From: Joe Robertson
Sent: 10 May 2016 17:11
To: Louise Clarke
Subject: 2016/90647 Former Station and Railway Goods Yard, Netherton.

Joe Robertson
(Tree Officer)

Drawing  
Outline Drainage Proposal

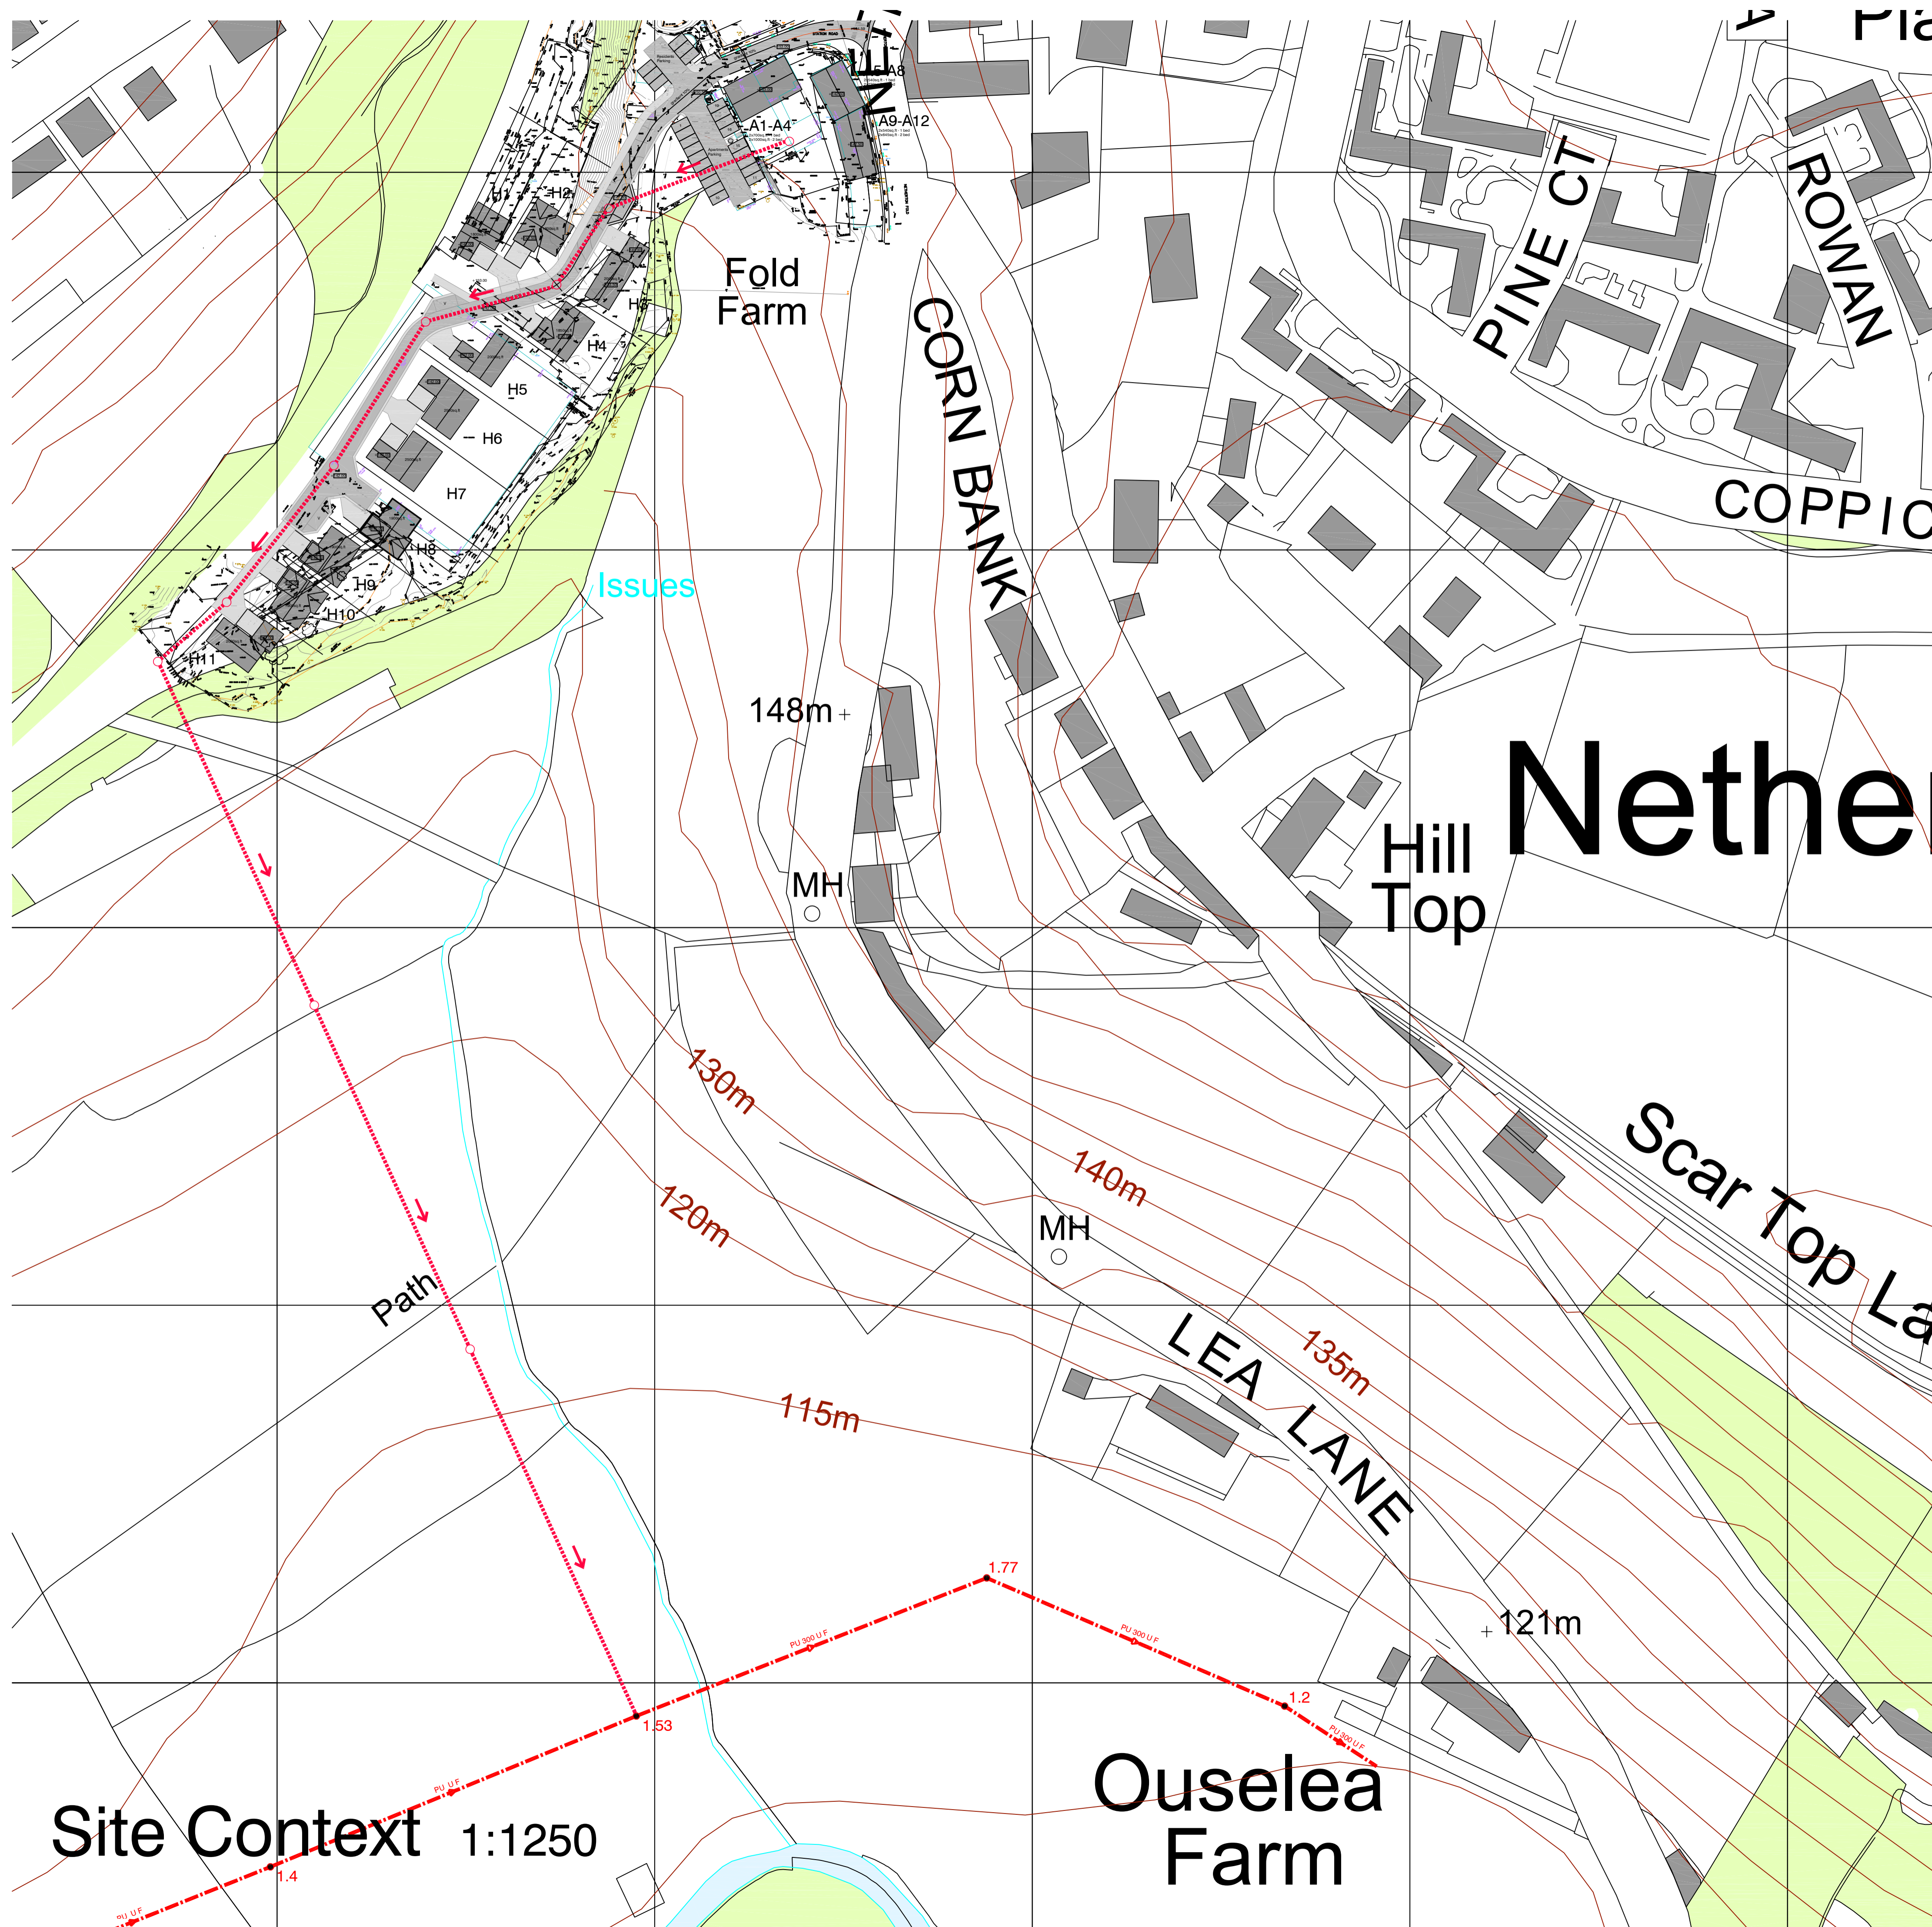
- The drainage plan shows the main drainage route cutting through what is now a TPO woodland. The track way which is only a few meters to the west of the current drainage route through the wood, is not part of the TPO'd woodland so there would be no issue placing the drainage here, providing there is a supporting method statement. However if the drainage can only take the route shown, then we would need to see a plan showing the drainage route, along with which trees to be removed, as well as the location of adjacent trees and their root protection area.
